## Application for a Non-Material Amendment Following a Grant of Planning Permission

Replacement dwelling house with two storeys and new basement level

63937/APP/2022/3692

Proposed new house
Elevations 2 of 2

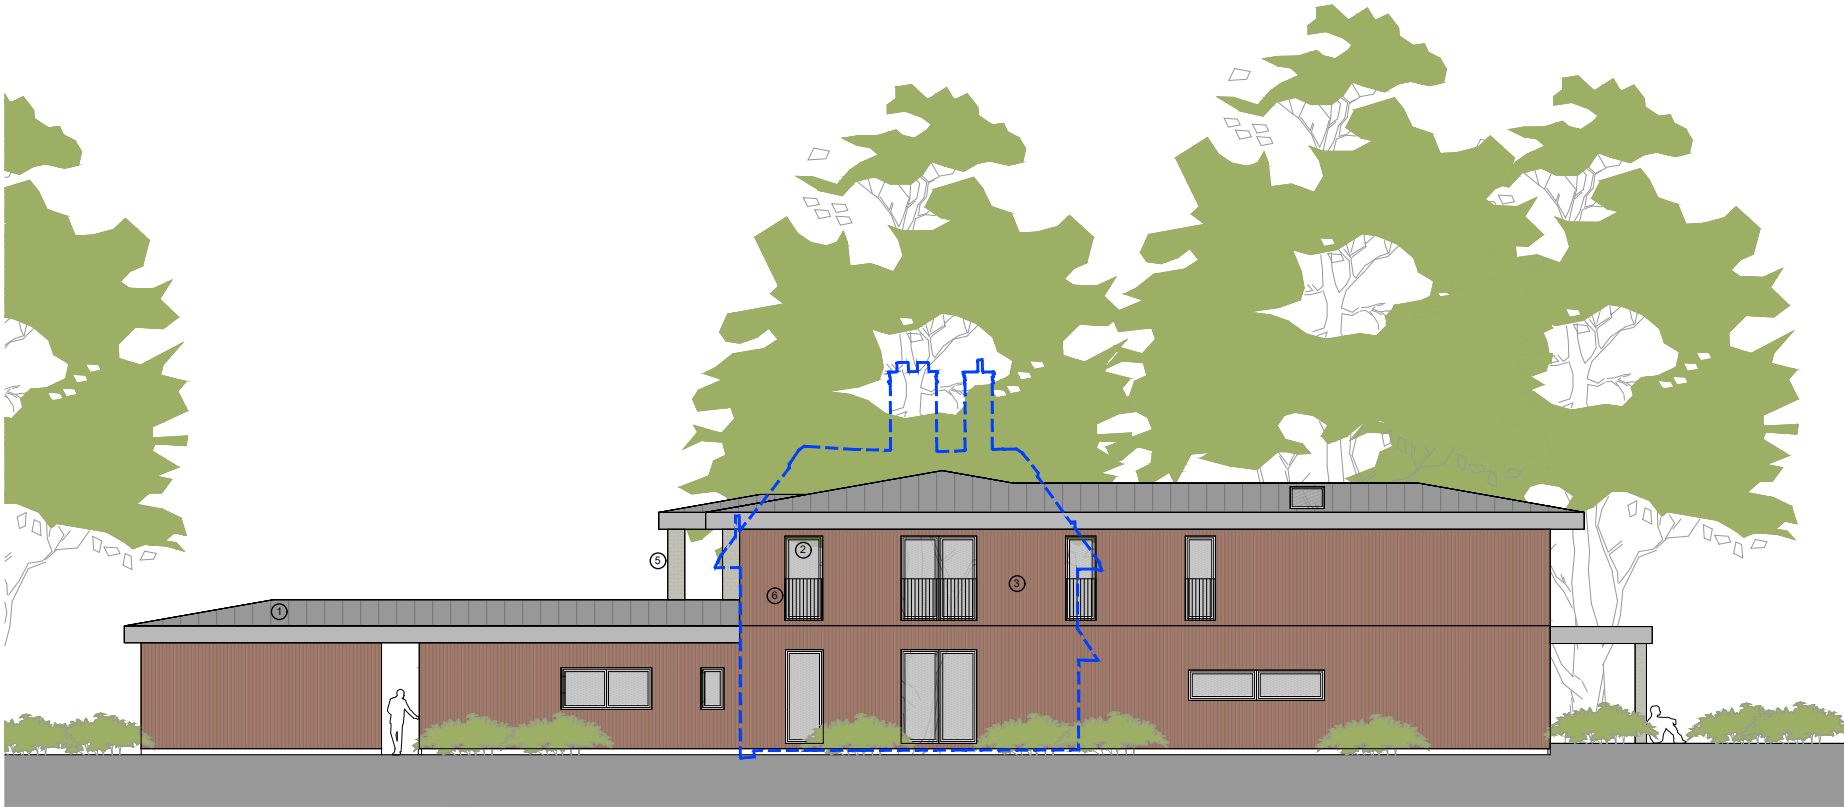
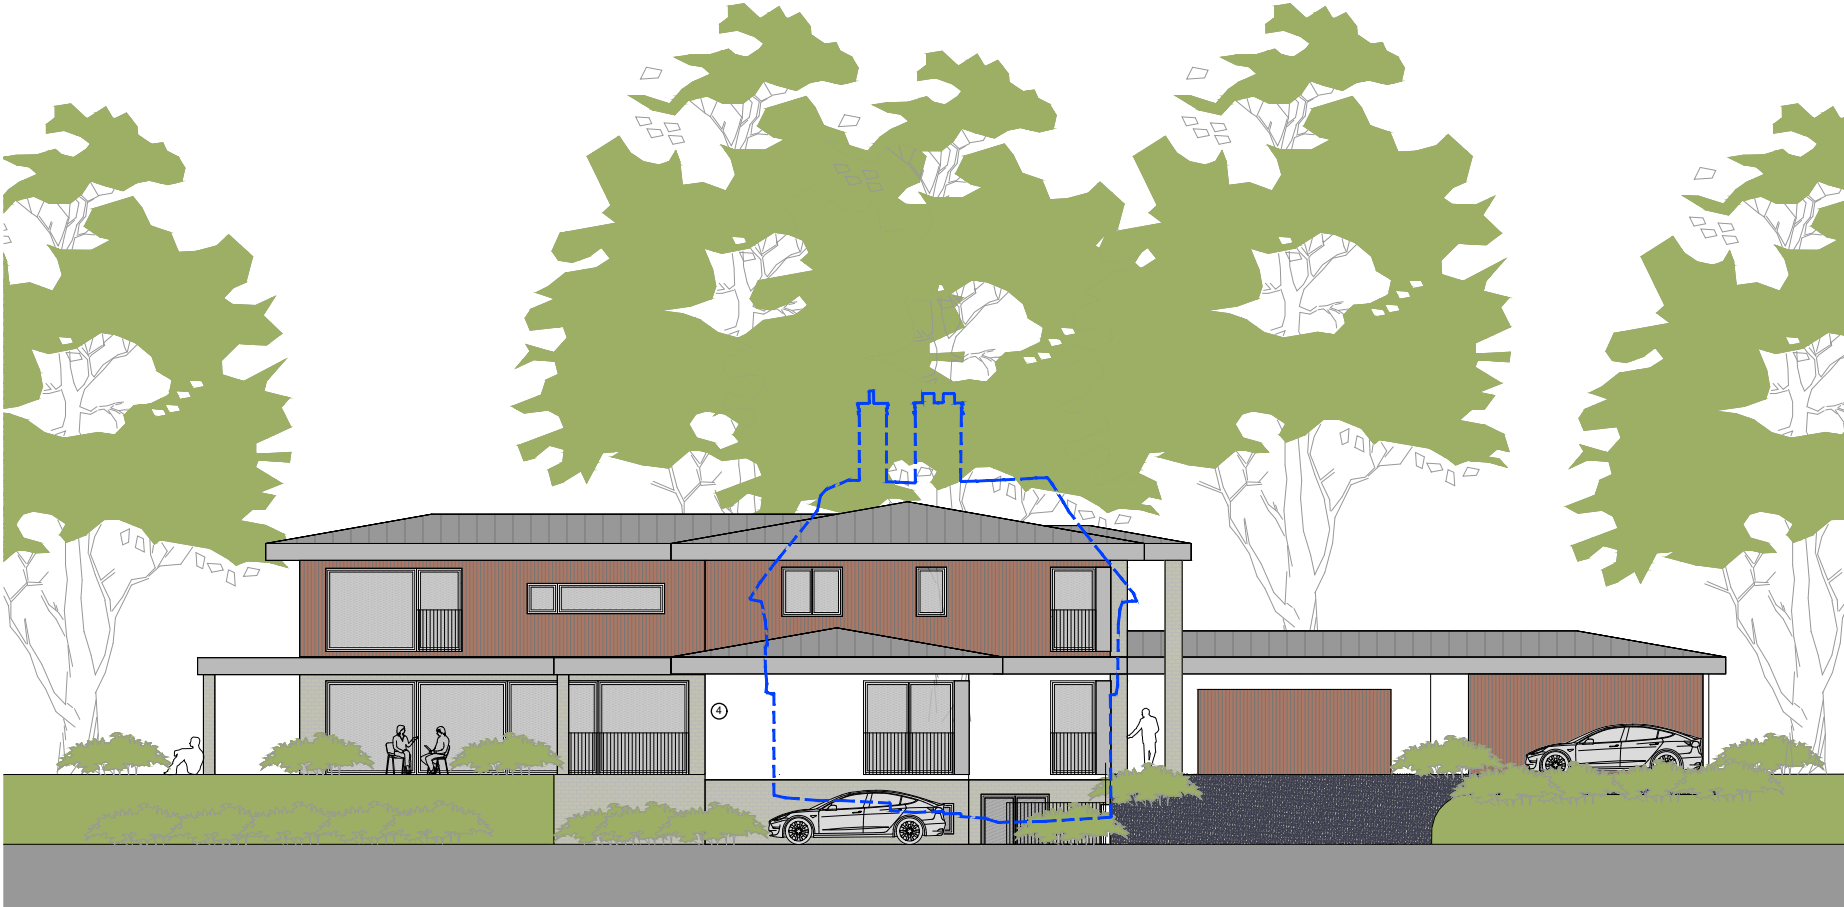
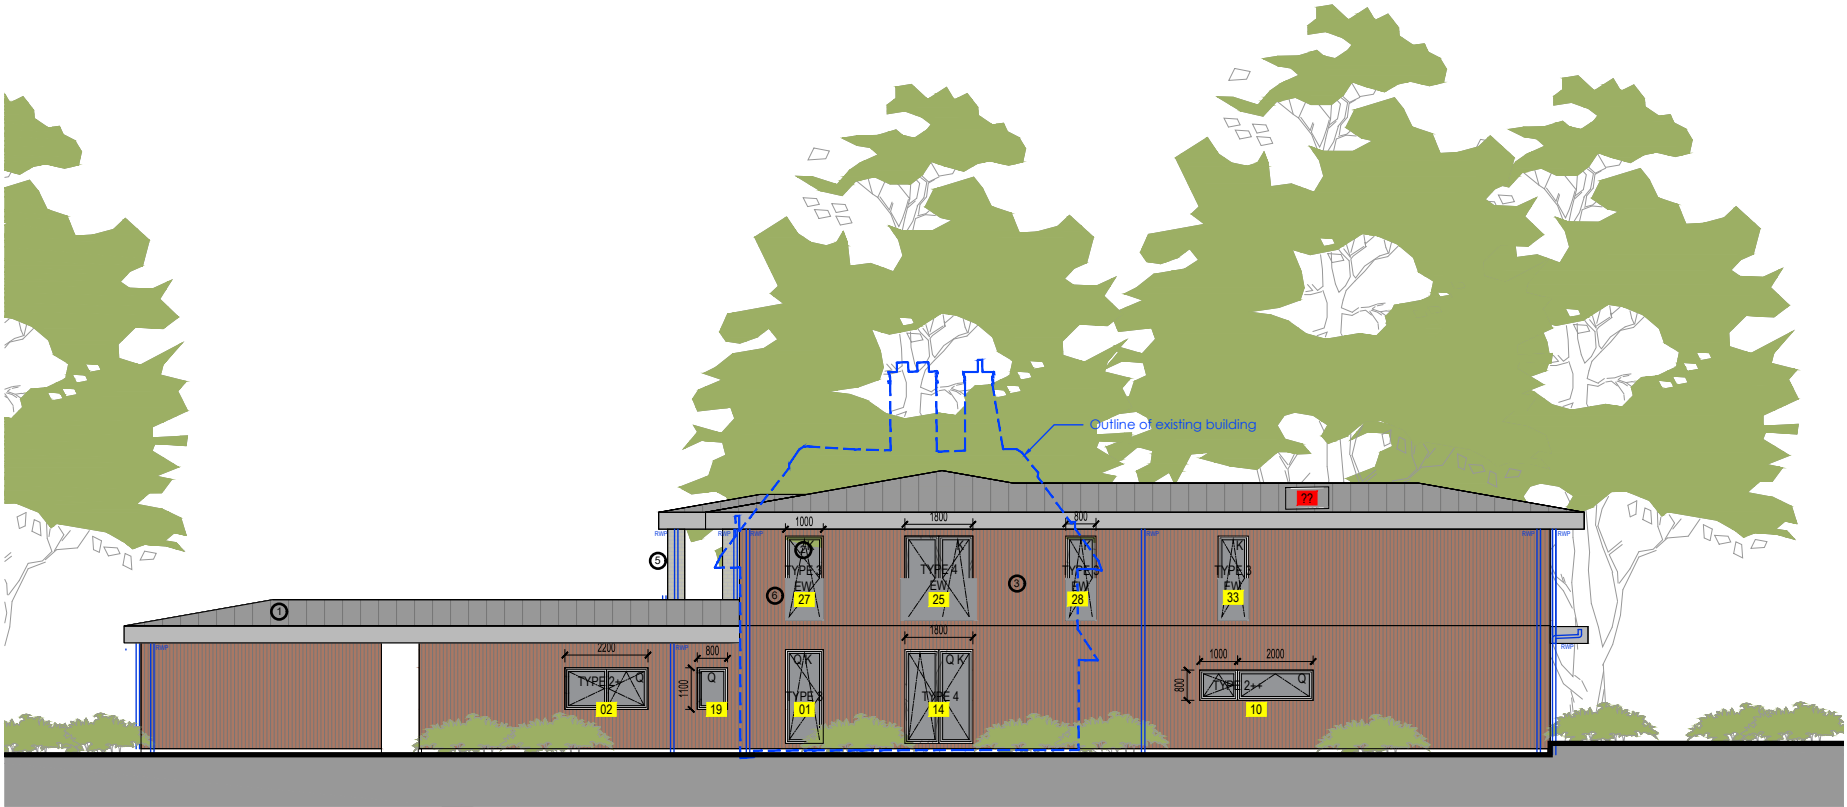
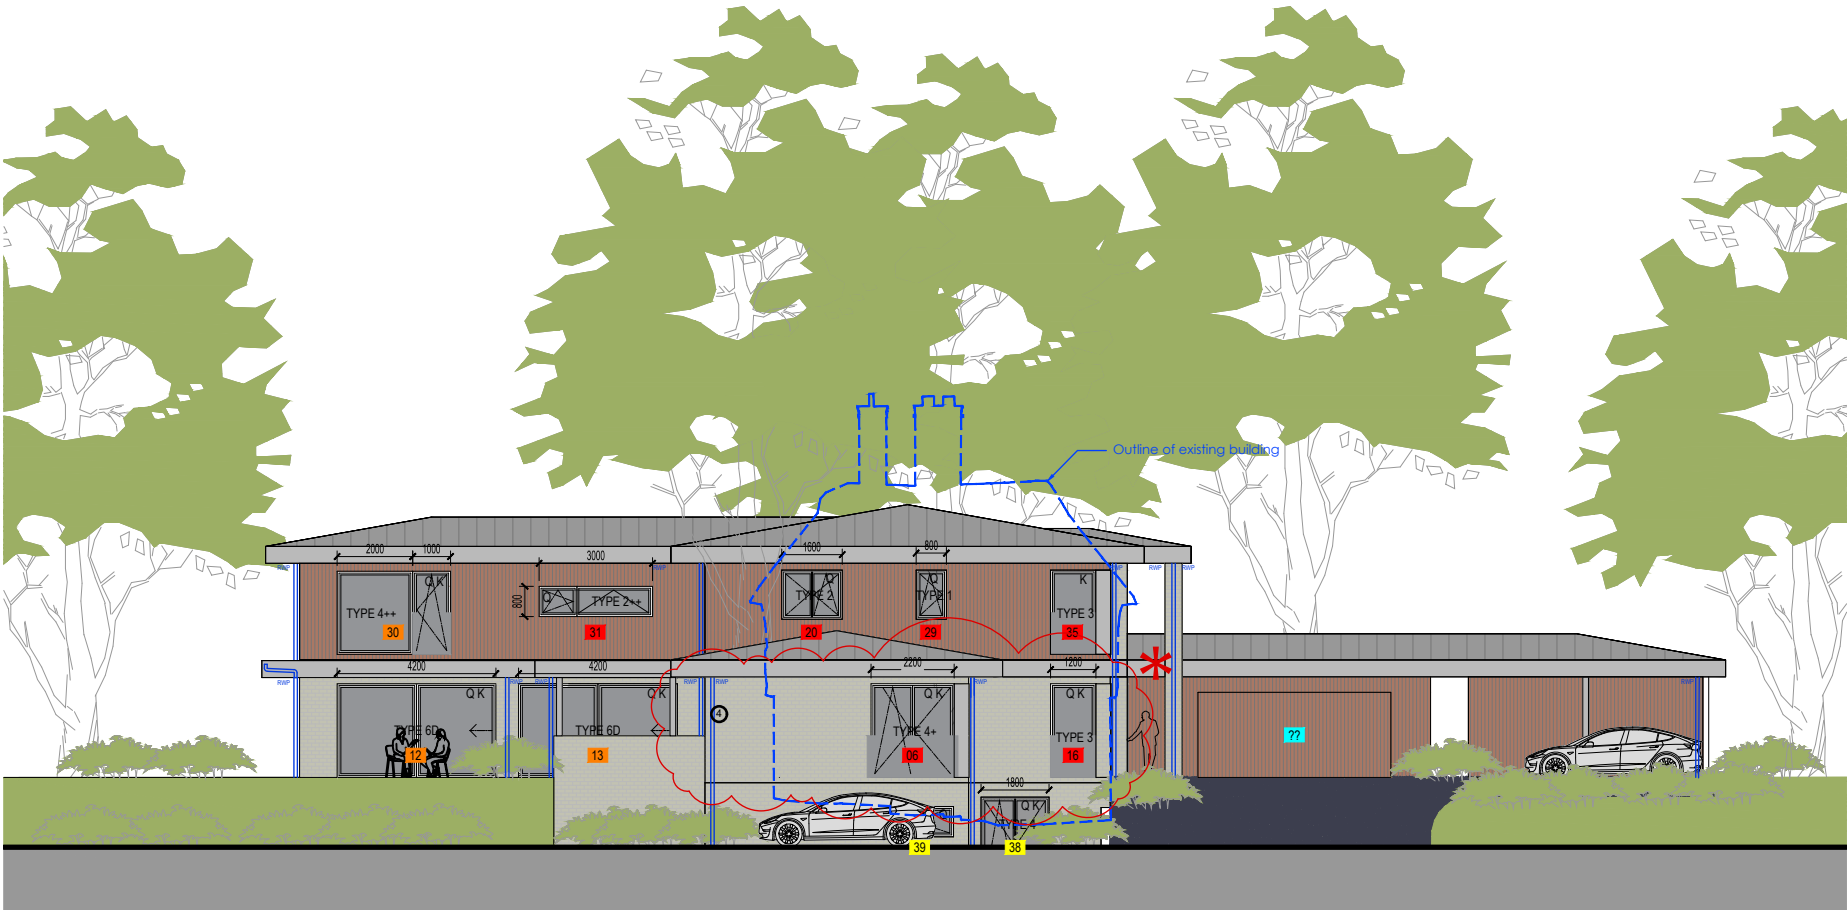
Design Development with the client during post planning meeting. The Eternit-type panels have been removed so as to simplify and enhance the elevations from quite busy facades with ave. 3 materials / finishes +glazing to 2 materials / finishes + glazing.

375-006-0 ELEVATIONS - SHEET 1  
375-006-0 ELEVATIONS - SHEET 2

375-006-D: ELEVATIONS - SHEET 1  
375-006-D: ELEVATIONS - SHEET 2
